Address: Langholme, 13 Lewisham Road Huddersfield HD7 5AL

Application number: 2022/93192	
What is the application for?:	Erection of detached communal room with glazed link (within a Conservation Area)
Address of the site or building:	Empire House, Lewisham Road, Slaithwaite, Huddersfield, HD7 5AL
Postcode:	HD7 5EX

Type of comment: An objection	
Do you wish your comments to be published on the website anonymously?	No
The design is not in keeping with anything else in the conservation area, nor being of any architectural merit in of itself it is visually out of place with the rest of the street and area as a whole. I am concerned that the shape and proportions of the building with its flat roof resembles more of a 'port-a-cabin' style temporary building that has tried to conceal itself with a stone foot and unnecessary and unbecoming painted plywood detailing, designed in a way that does not in anyway match nor enhance any neighbouring building on the same site nor the surrounding area. One of the most defining features of this period of buildings is a slate tiled roof, something on the original approved planning application, and recommended by the conservation officer, which would

Proposed front elevation (1:100)

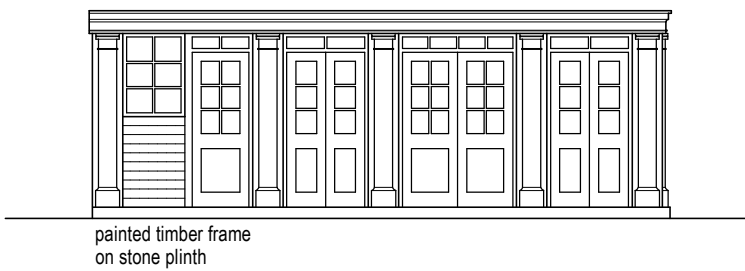
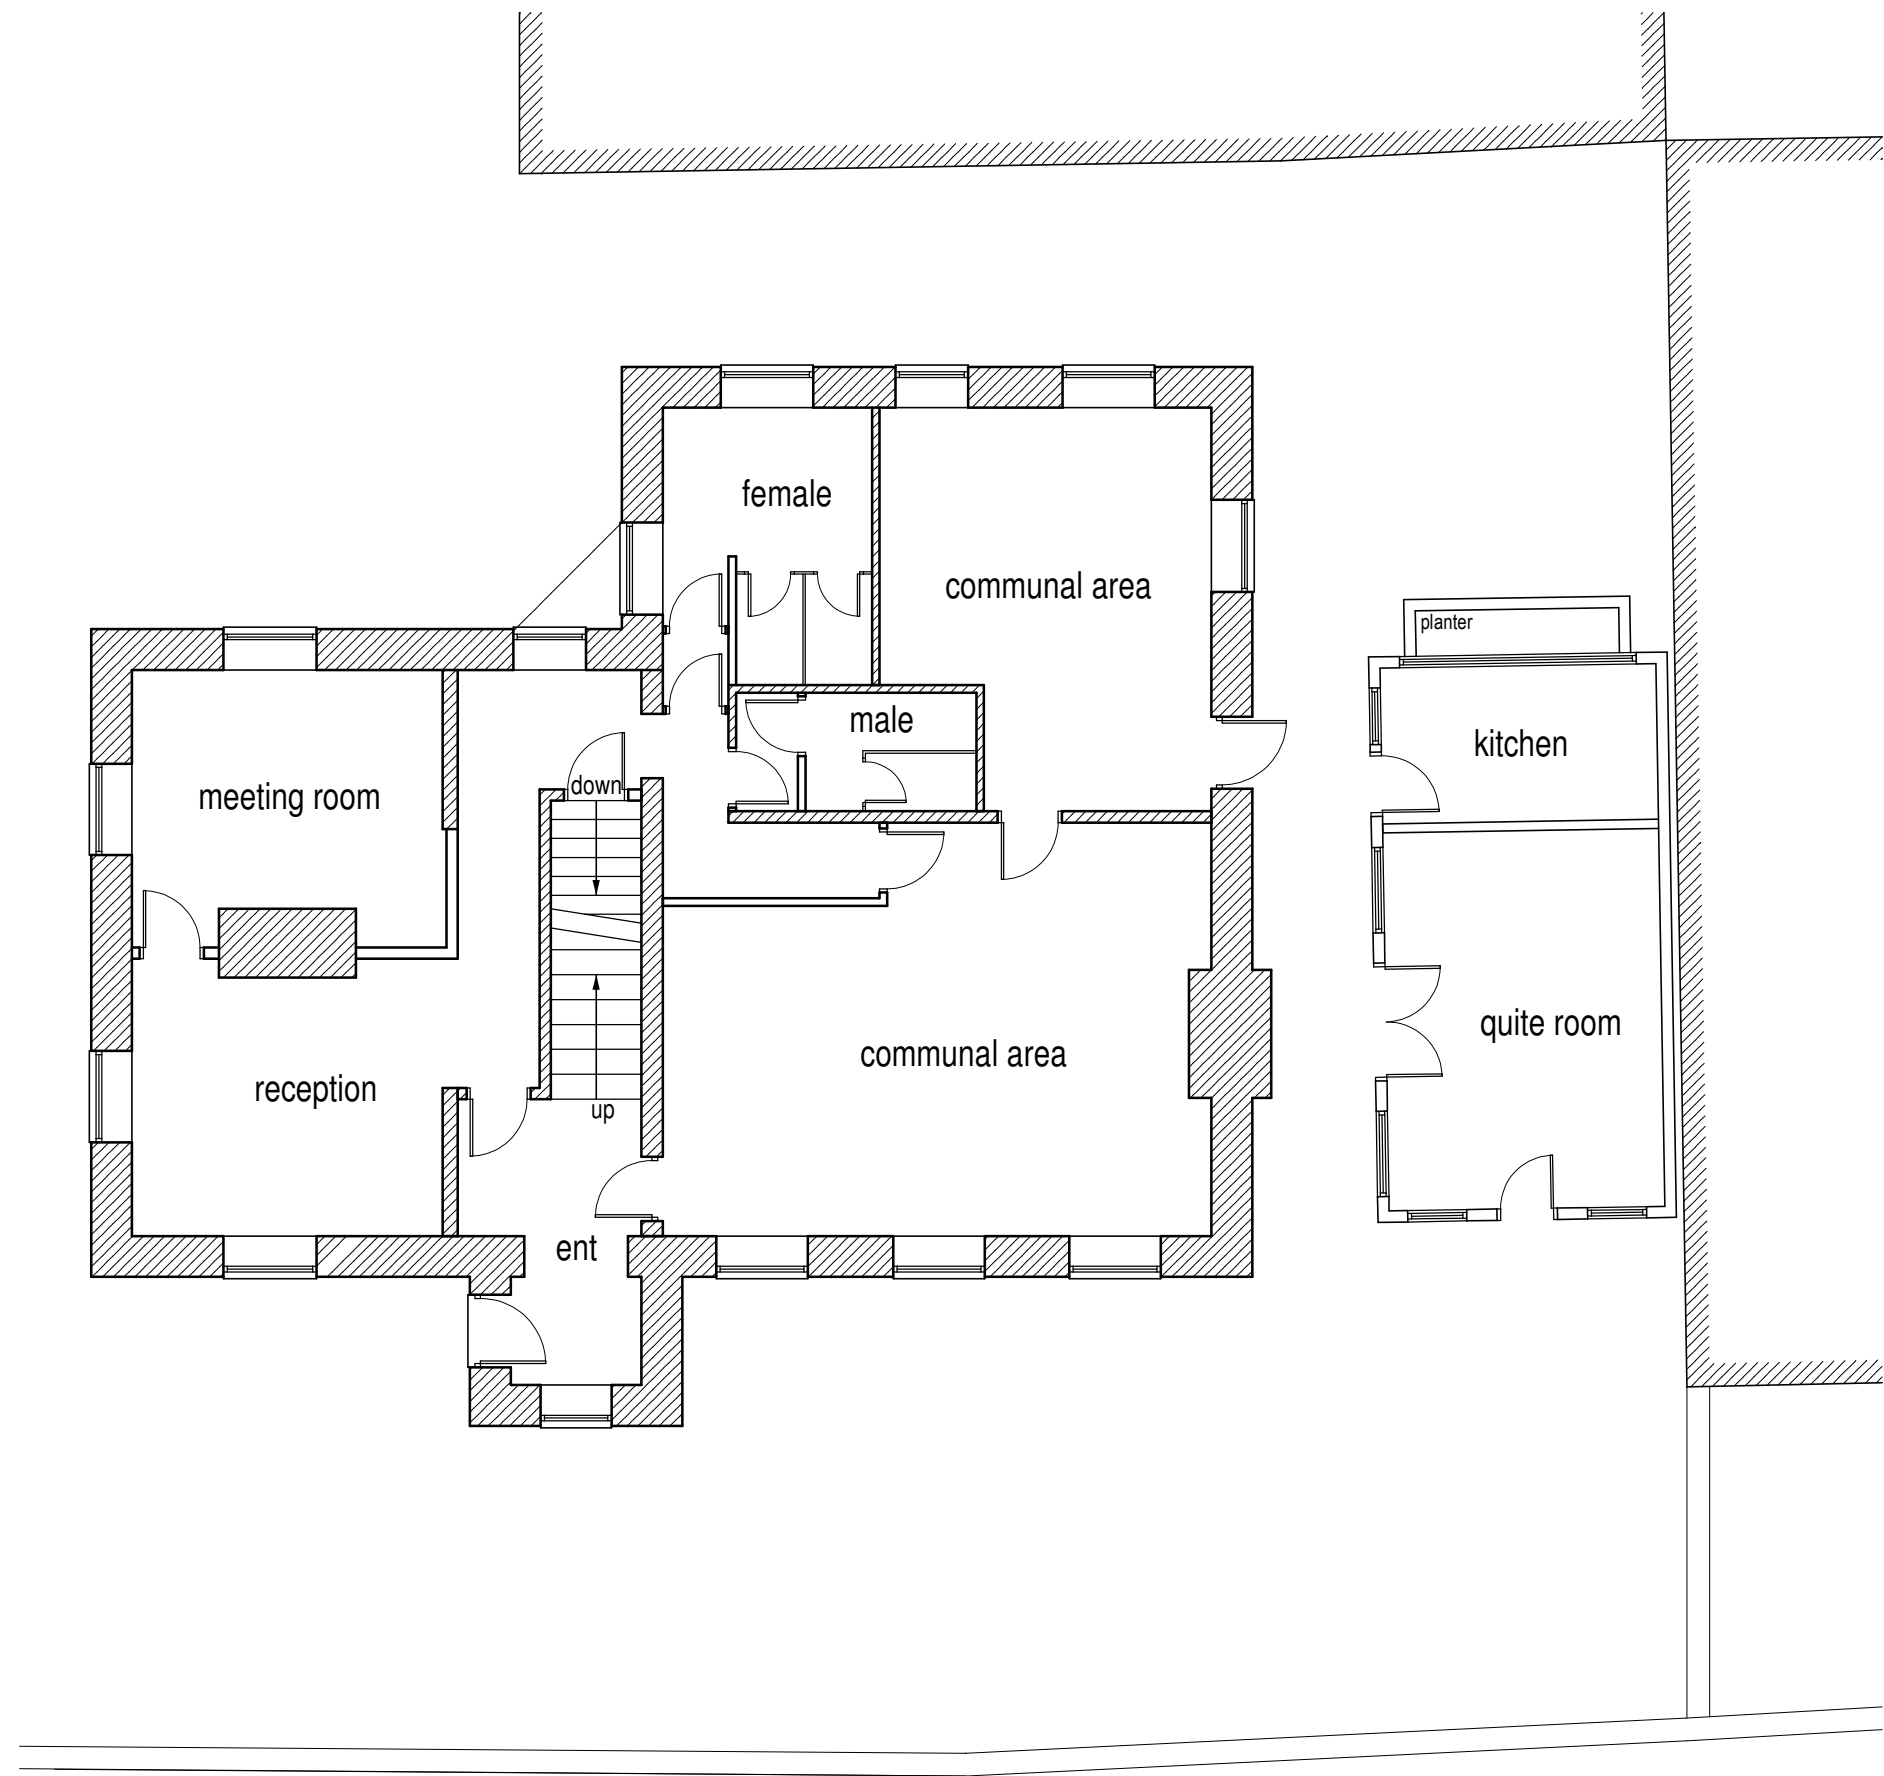
Due to the height difference of the land and the placement of the windows at the front elevation of the 'quiet room' means the front garden and entrance to the neighbouring property is easily overlooked from within the new building from all 3 windows.

Massively impacting the privacy of the residents disturbing their day to day lives.

Setting the building further back from its proposed sight and or installing frosted / obscuring glass would limit this invasion of privacy.

Proposed ground floor layout (1:100)

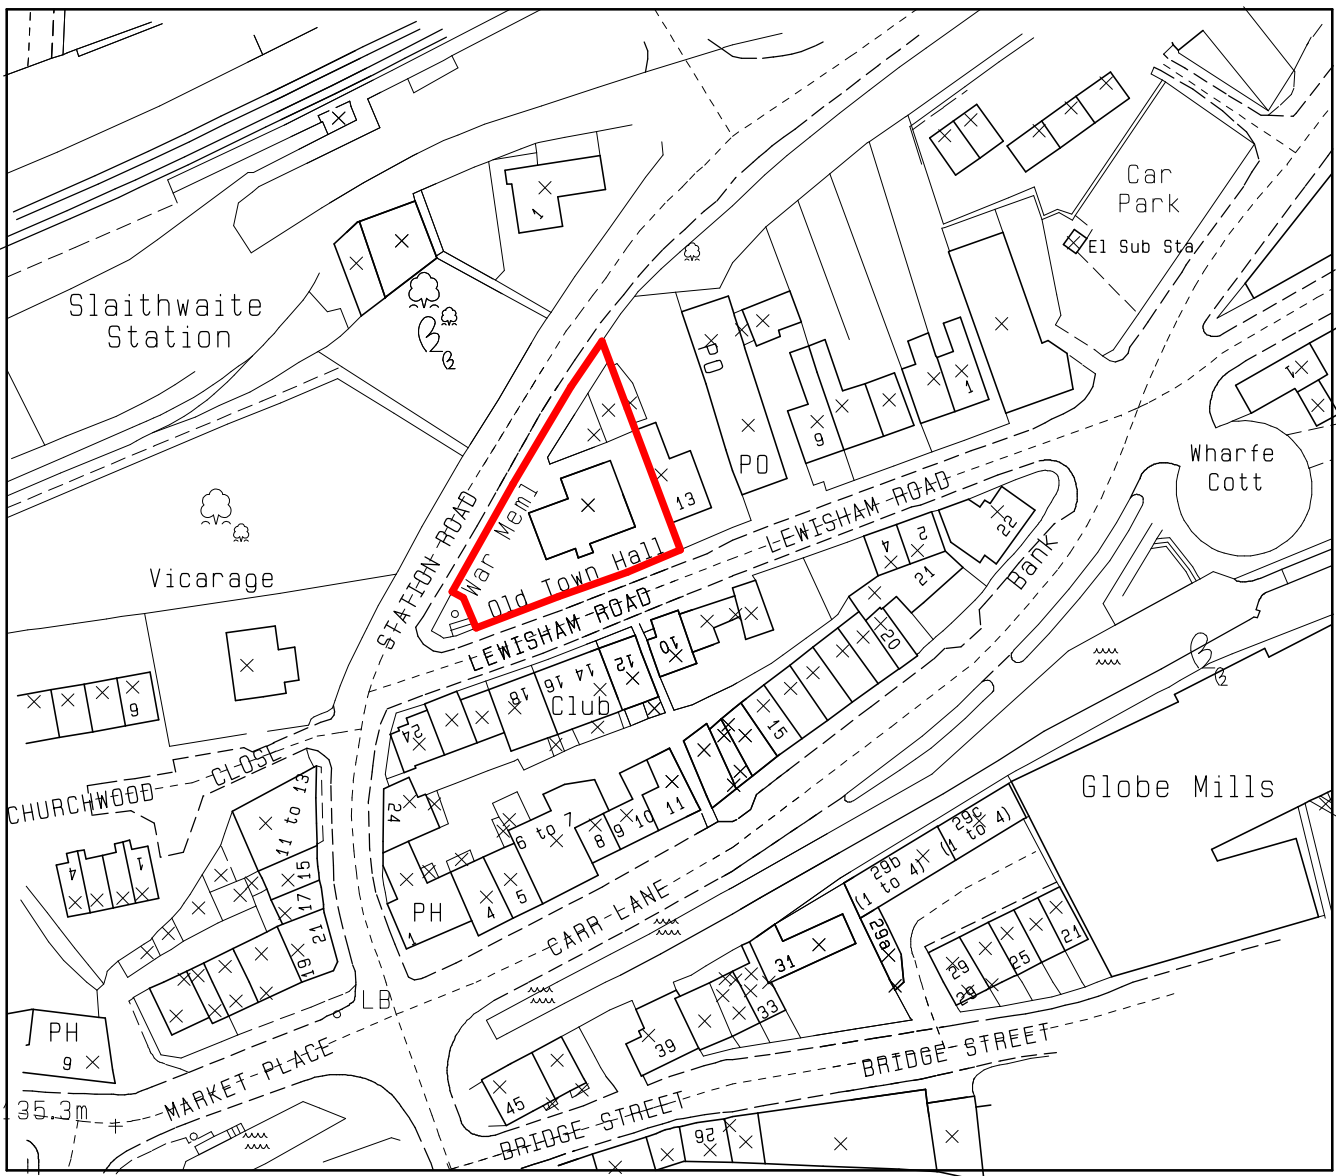
The kitchen is directly below the bedroom window of the neighbouring property and the bedroom is greatly impacted by unwanted odours and noise.

There is no way to assess or carry out any necessary repairs to the external wall of the neighbouring property, No.13, due to the unnecessarily close proximity of the building. Being less than 50mm away, the natural wear and tear and weathering upon the stone work and mortar will still take place, without physically providing enough room to carry out any repairs at any point in the future to a very large section of masonry work. However as the building began construction at the beginning of September 2020 before planning approval was given any assessment of condition and or relevant repair or maintenance work was not made possible. Sighting the building away from the neighbouring wall as to provide enough room for maintenance and repairs to be carried out.
